DECISION DELEGATED TO HEAD OF PLANNING

Application No: H09-0544-25 **Applicant:** Mr & Mrs M Clark
Proposal: Rear extension to dwelling
Location: Fair View Holbeach Drove Gate Holbeach Drove
Terminal Date: 29th July 2025

PROJECT NUMBER :
J25175
 DRAWING REFERENCE :
PL01

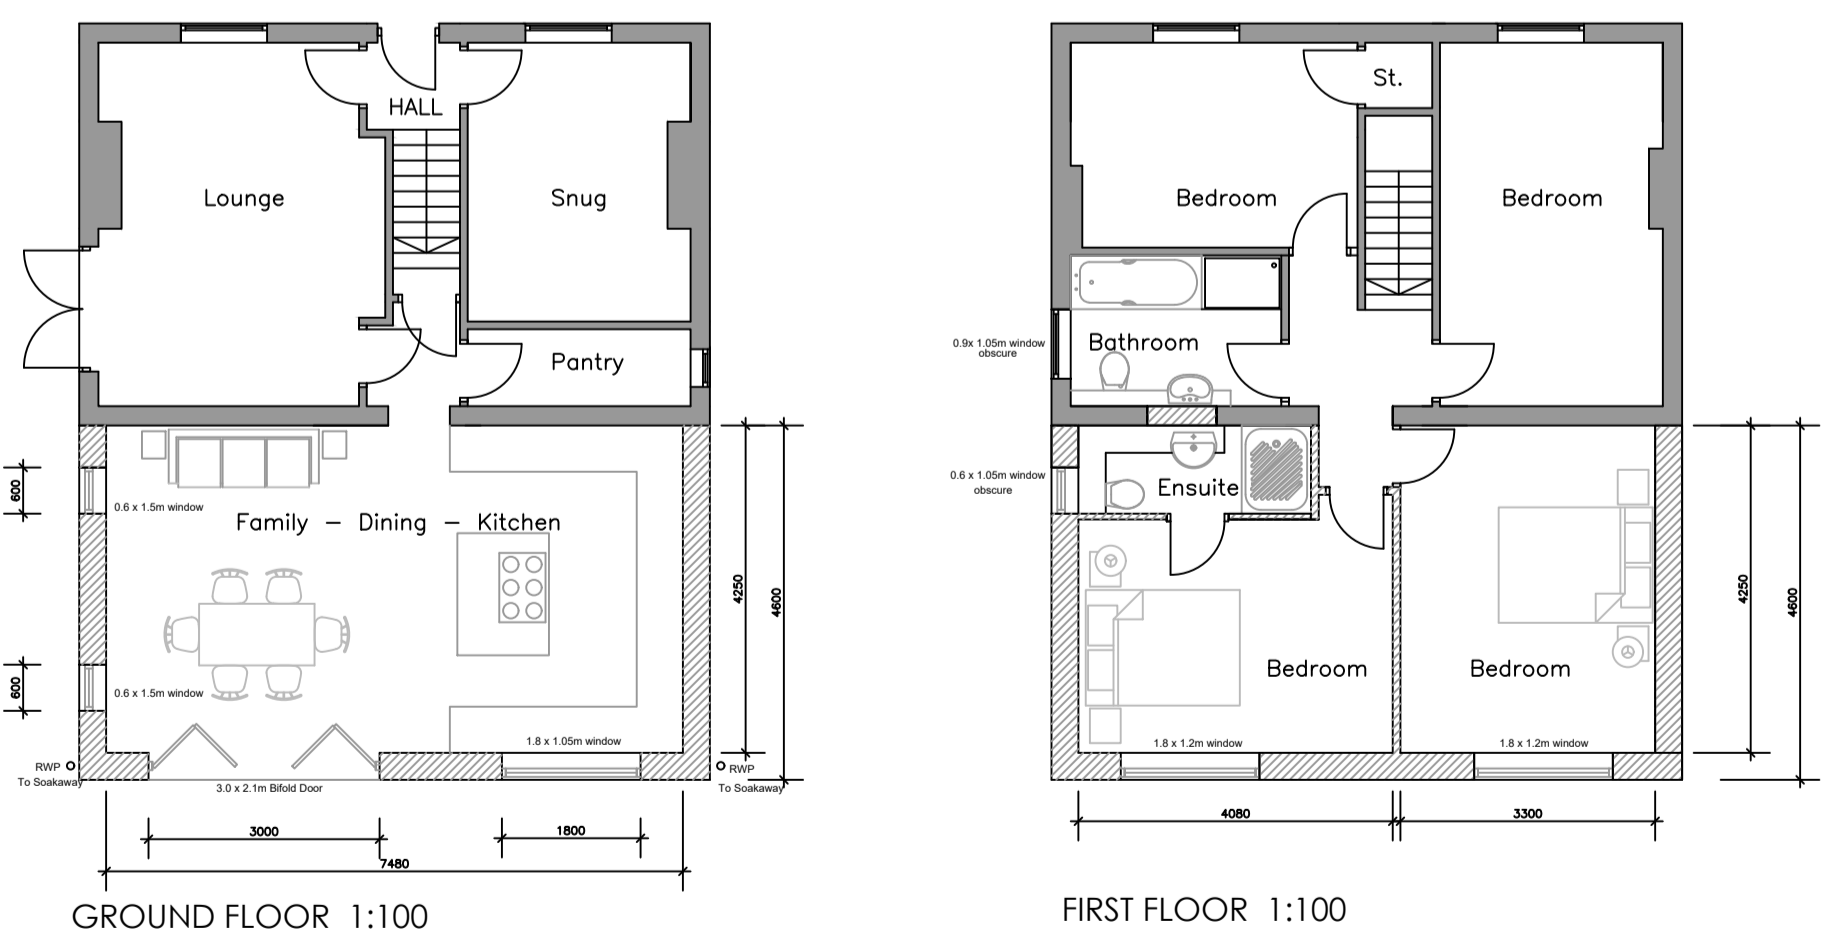
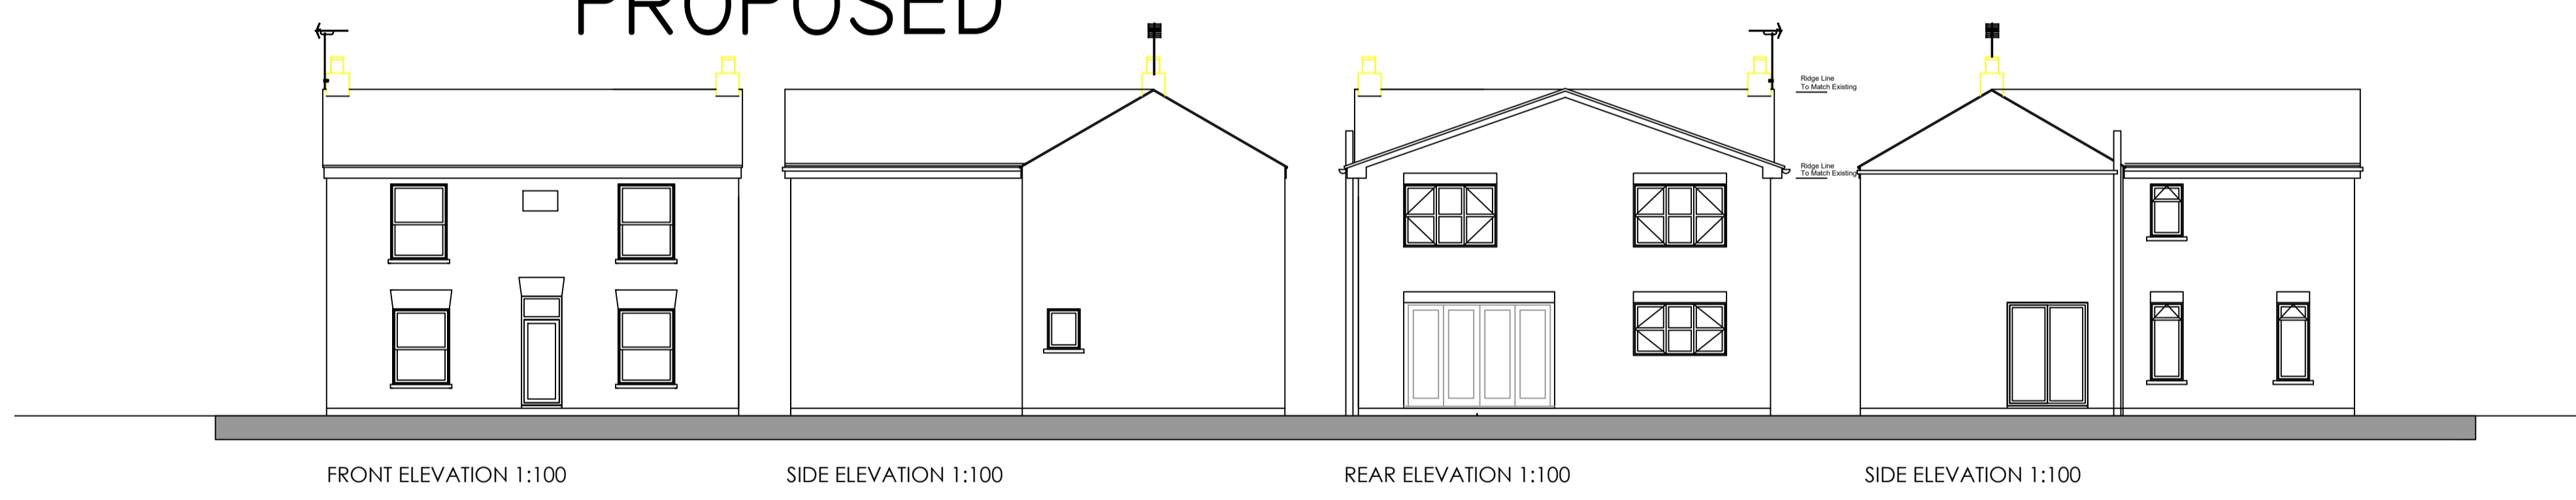
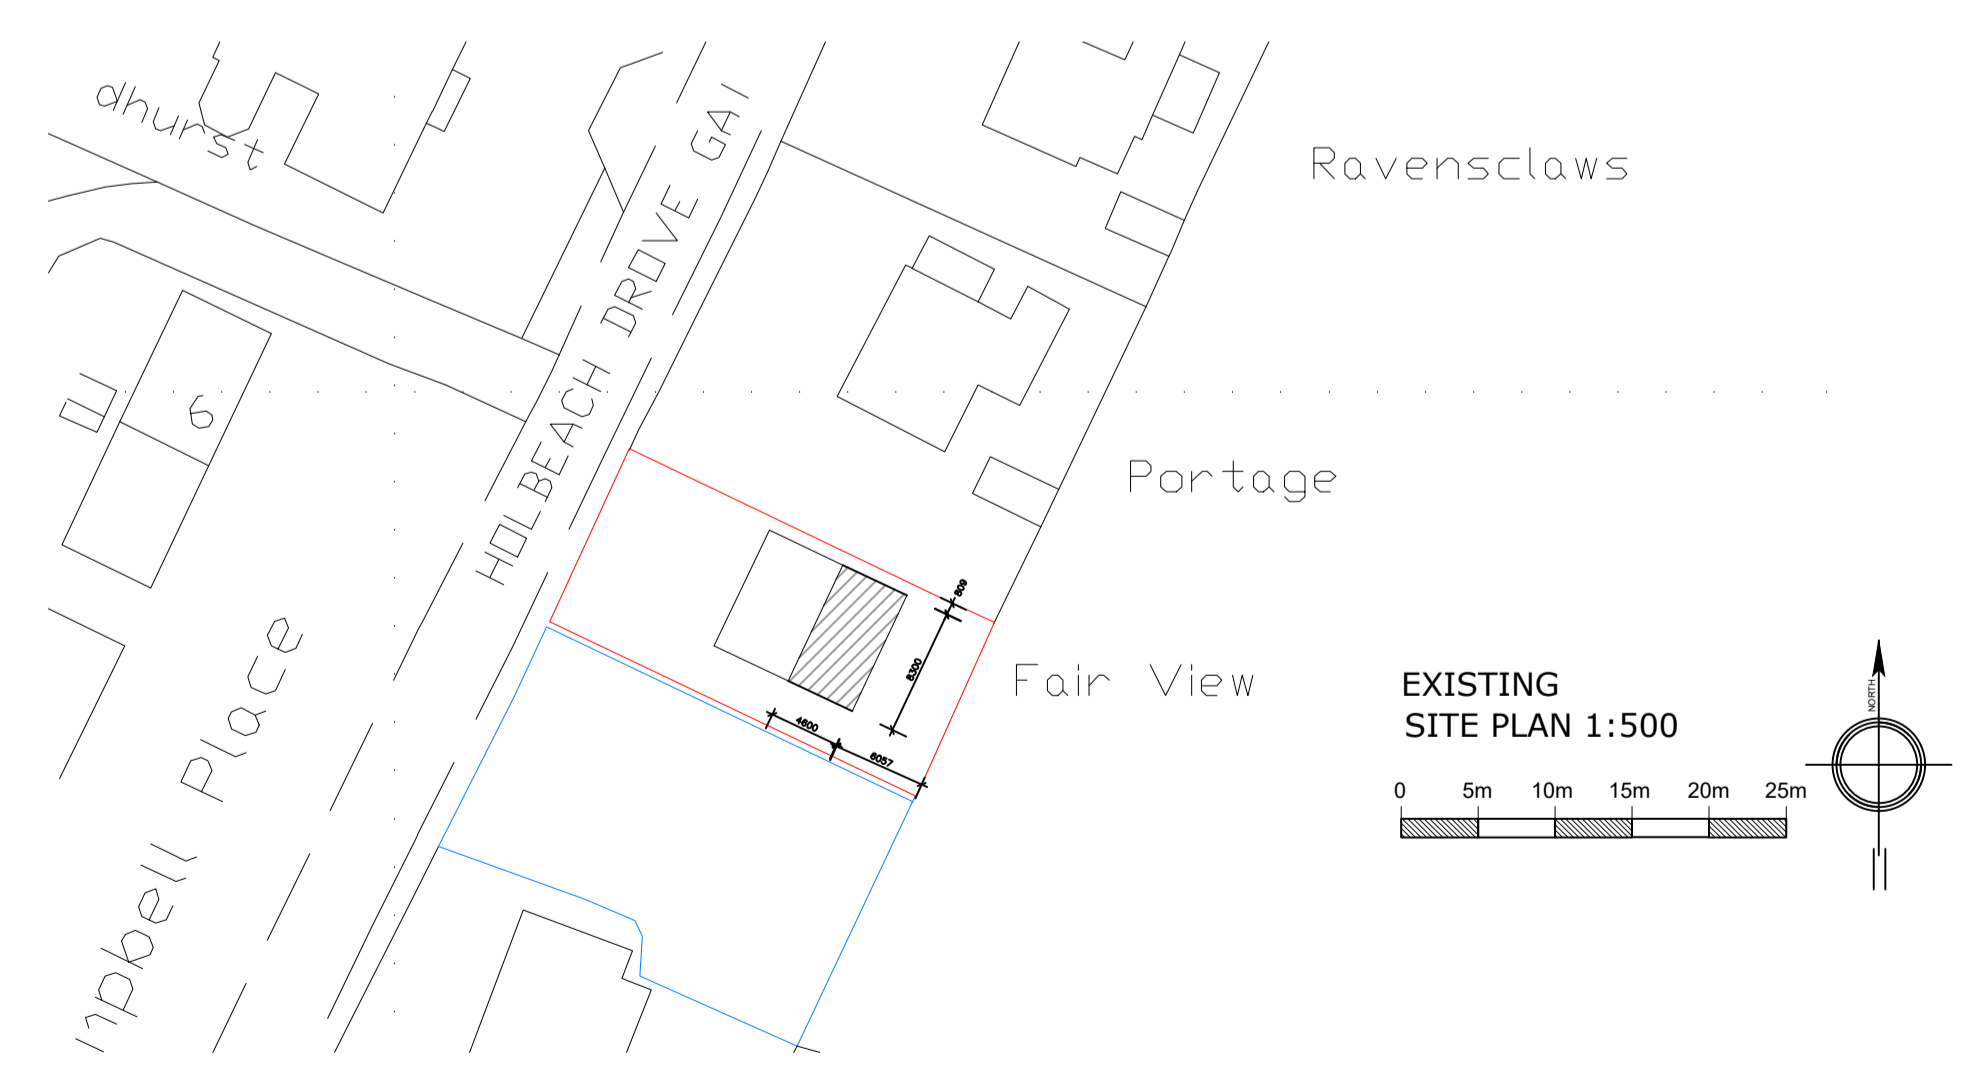
The existing dwelling comprises a detached two storey dwelling, with a gable end roof form. The dwelling features a single storey rear extension which measures 7m by 2.6m, and a lean-to rear extension which measures 1.7m by 2.5m. Both of these extensions are proposed to be demolished to make way for the proposed two-storey rear extension. The proposed extension measures 4.6m by 7.48m. The height and eaves of the extension would match the main dwelling.

Extensions should not dominate the original building in terms of their scale or siting. Extensions should also generally be subservient and proportionate to the original building. In this case, it is not considered that the scale, siting or appearance of the extension would be acceptable. The scale of

the extension would be excessive. The extension would be as tall as the main dwelling and feature the same width. Whilst this might be acceptable in some cases such as single storey properties, in this case, the overall scale and bulk of the extension is considered to comprise a disproportionate addition, which would visually dominate the host dwelling.

The proposed materials for the extension are not set out within the submitted plans, however, the application form sets out that the proposed facades would feature 'Weber Mushroom' render. The existing dwelling features red brickwork. According to the application form, the existing brickwork features an imperial measurement and as such, any brickwork on the extension would not match up due to the different coursing that is used. Whilst this is acknowledged, it is not considered that the proposed rendered facades would be suitable in this case. The proposed render would exacerbate the harmful impact of the extension on the street scene by adding a disproportionate and visually incongruous addition to the dwelling that is not in keeping with the character of the host dwelling or the surrounding built environment.

The proposed extension would be of an excessive scale compared to the main dwelling and the proposed rendered facades would exacerbate the visual harm of the proposals. The extension is not considered to be a suitable or sympathetic addition. Furthermore, the limited benefits of the scheme would not outweigh the visual harm that would arise to the locality. As such, the development would cause an adverse impact on the character and appearance of the area and would therefore not accord with Policies 2 and 3 of the Local Plan or Section 12 of the NPPF.

The proposed development would comprise a disproportionate addition to the host dwelling. The scale and design of the extension is considered to be unsuitable, comprising an excessively large form of development which would be significantly at odds with the character of the area and harmful to the street scene. The proposed rendered facades would further exacerbate the visual harm of the proposals. Therefore, the development would comprise an unduly dominant and incongruous development.
